Traffic Impact Study

Date: July 22, 2026

Fall Mountain Farm

El Paso County, Colorado

Figure 3 - Site-Generated Traffic Volumes

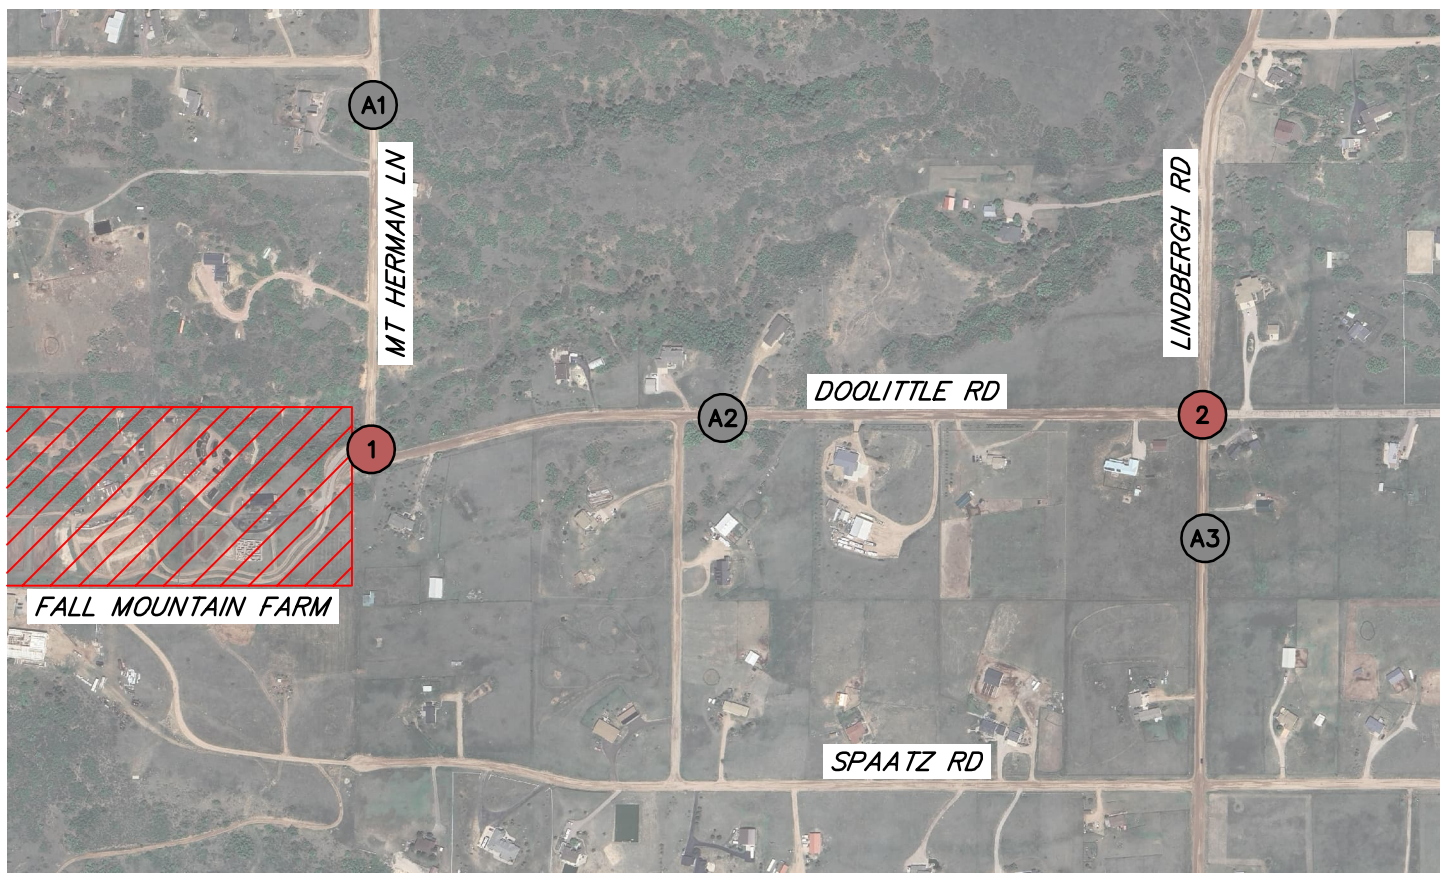
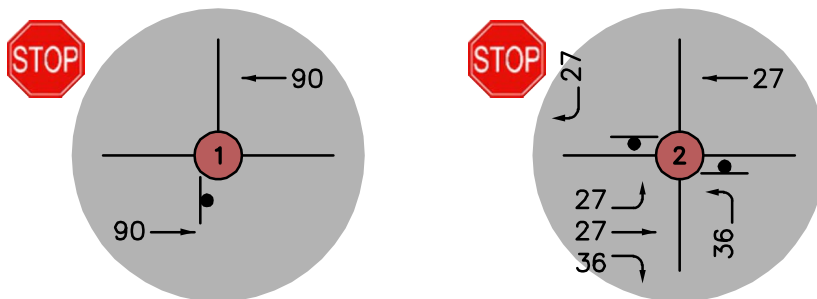
Please clearly state how the site generated ADT was calculated as this section is only focused on peak hour. The site generated ADT used seems low compared to the ticket sale data and the peak hour trips.

91 per narrative in Site-Generated Traffic Volumes Section on Page 8 and Hourly Vehicle Traffic counts on Pages 26 and 27. Please revise.

Figure 4 - Total Traffic Volumes

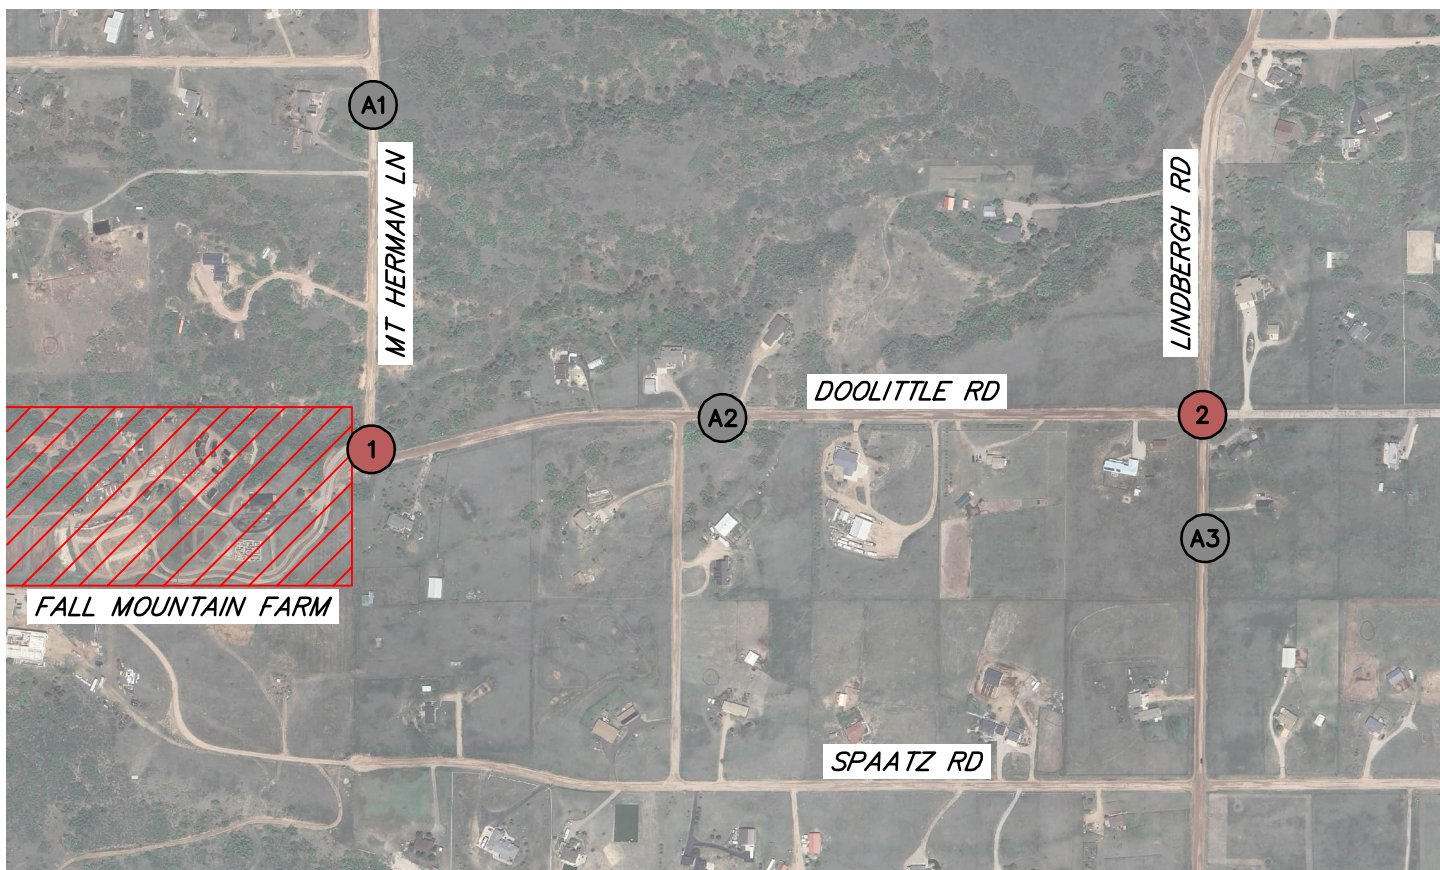
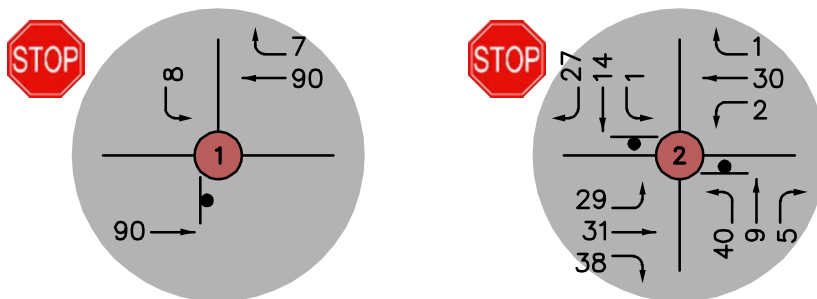
It seems like this should be total traffic.

It seems like this might be total traffic based on page 13. I agree with the assumption that we would not anticipate there to be much growth over time in this area.

Clarification on the following chart's legend. F = Friday, S = Saturday, N = Sunday

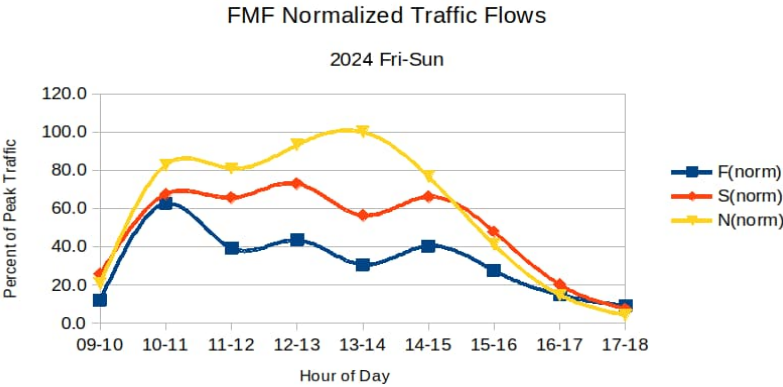
If this was counting ticket sales instead of vehicles, please revise to be correct.
